Our Ref : JC/13/09/1490-L1

Date : 11th November 2015

**RE:- STRUCTURAL ENGINEERING SERVICES;-
BARN AT RAVENS BANK, WHAPLODE ST CATHERINES, SPALDING
APPENDIX TO STRUCTURAL REPORT REFERENCE JC/13/09/1490**

EXISTING RIGHT FLANK ELEVATION (1:25)

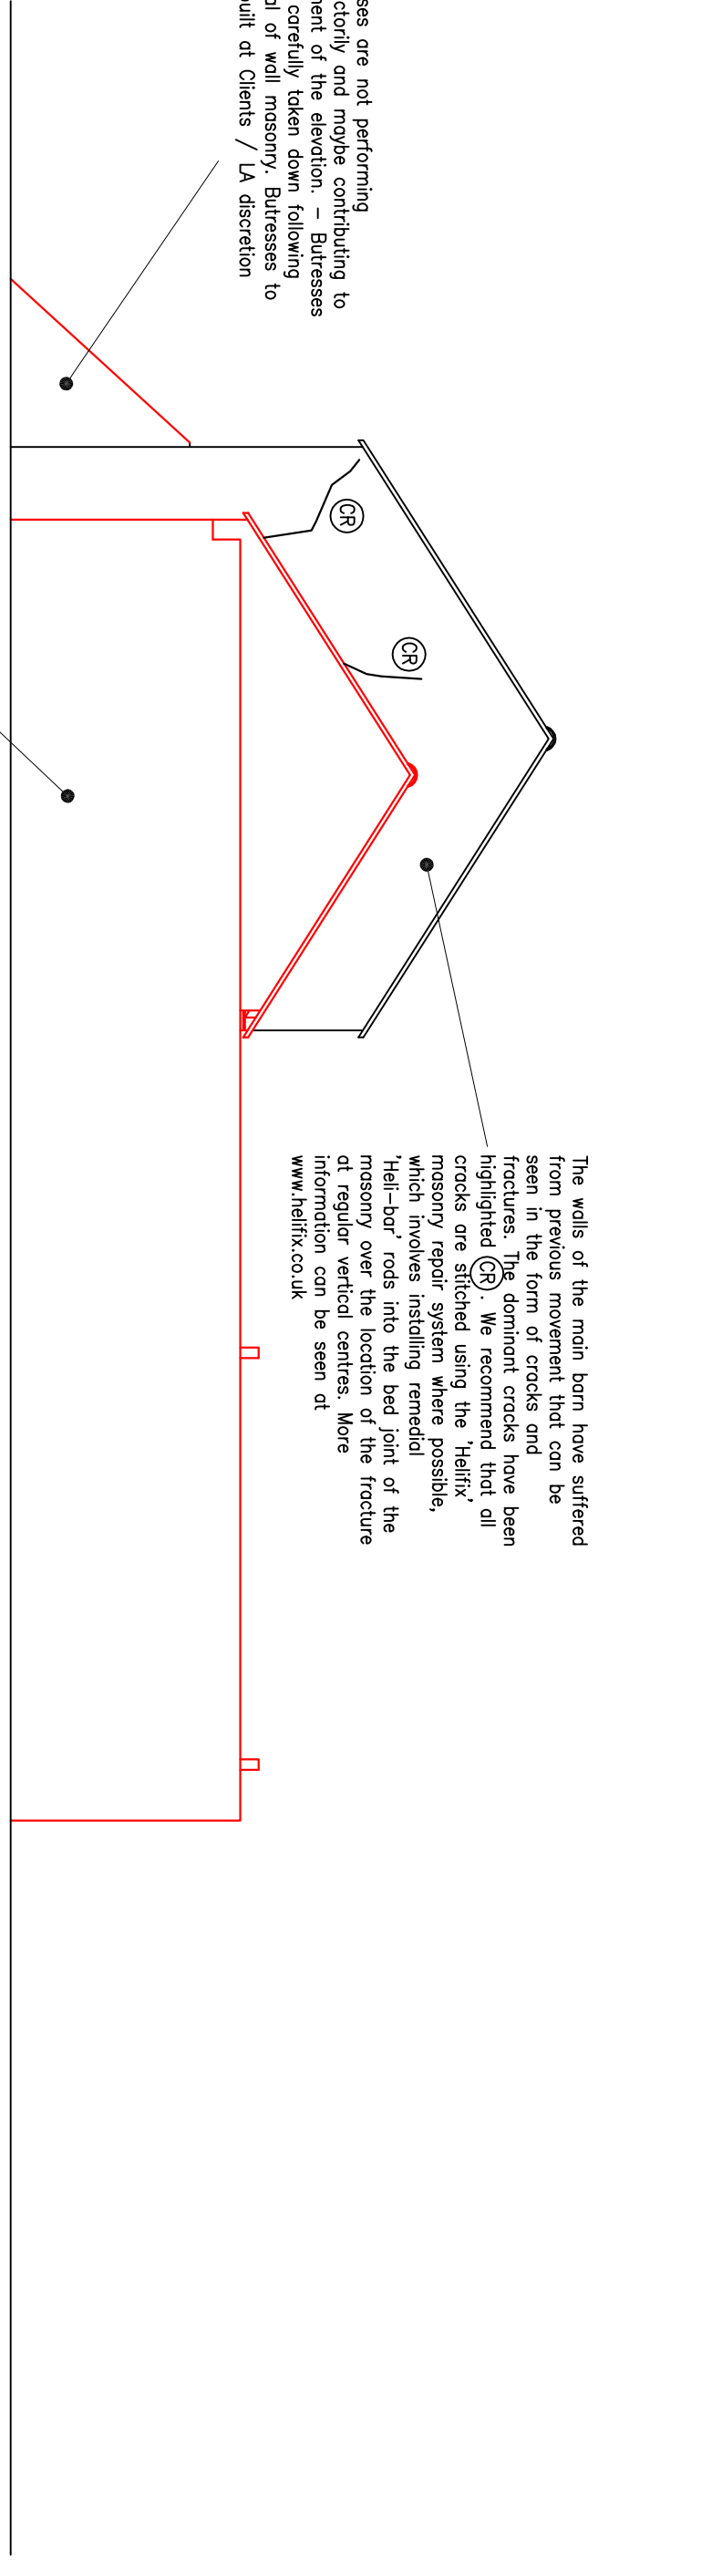
- Following on from our survey in 2013, the ivy has now been partially cleared from this elevation. It is apparent that this wall has continued to accommodate a degree of movement over the last 2 years. The cracking at its returns with the gable elevation has opened up considerably and the outward lean accommodated by the wall has increased.

- The movement and subsequent stresses have been sufficient enough to pull on the masonry tie bars, as pattress plates have dished in their housing, and have partially pulled out of their sockets.

- In addition, the wall appears to have rotated slightly on its foundation as gaps are now present at its junction with the existing ground floor of the barn.

- The wall panel of this elevation is now in a poor condition. Much of the panel around the large door opening has been, in the past, rebuilt. 'Common' style brick units have been used and a high degree of the resultant movement can be seen around this in-filled panel in the form of cracking.

- The wall is accommodating on going movement. We inspected the other remaining walls of the two storey element, and there has been very little change in their appearance or condition when compared to the 2013 survey. With this in mind it appears that the movement is localised to only the right hand side elevation flank wall.

- The likely catalyst of the ongoing movement is almost certainly contributed by continued softening of the ground around the base of the wall whilst the building has been in its state of neglect. With no efficient means of discharging rainwater being installed on the barn, it means that there has been continued wetting and softening of the ground adjacent the base of the walls. Our latest visit was during a time of inclement weather and the ground adjacent this elevation could be described as saturated. The ground levels dip in this area when compared to the opposite elevation, so there is the possibility that after high levels of rainfall, water collects in this area.

- In addition, the current performance of the large buttresses needs to be considered. Whilst they would have presumably originally been installed following an episode of movement, their assistance at present appears to be lacking. The buttresses are reasonably large. As such their own self weight and subsequent settlement may be contributing to the lateral movement of the wall.

Firstly, in its current arrangement, i.e prior to conversion, the stability of the wall cannot be guaranteed. We are concerned that its movement is exerting stresses on the other walls within the barn, i.e by tension through the masonry units and tie bars. Whilst the other walls are principally sound, they will be vulnerable to the excessive forces produced by a wall that is progressively moving. Attempting to stabilise the wall by adding more ties will only compound the vulnerability of the other walls.

Secondly, following conversion, it was our original intention to stabilise the wall via the installation of the steel frame. Now that the wall is leaning more considerably, and we are aware that the movement is progressive, we are concerned that the transfer of loadings through the frame will again impact the other walls and potentially the finishes to within the completed barn.

Taking into consideration our observations and conclusions we strongly recommend that the wall is carefully taken down and reconstructed off the proposed raft foundation that is being installed as part of the proposed remedial works. This will help to relieve any stress from the remaining walls and should avoid potential movement in those walls in the future.

The original brick units can be reused within the re-build; however you may want to find replacement units as opposed to using the 'common' type bricks that have been previously replaced in parts of the existing wall.

As discussed the buttresses do not appear to be performing adequately and therefore we recommend that they are also carefully taken down as part of the proposals. If desired for aesthetical purposes, the buttresses could be reinstated. However, if you do decide to re-construct the buttresses, they should be built off a suitable foundation of which we can advise you on prior to commencing the works.
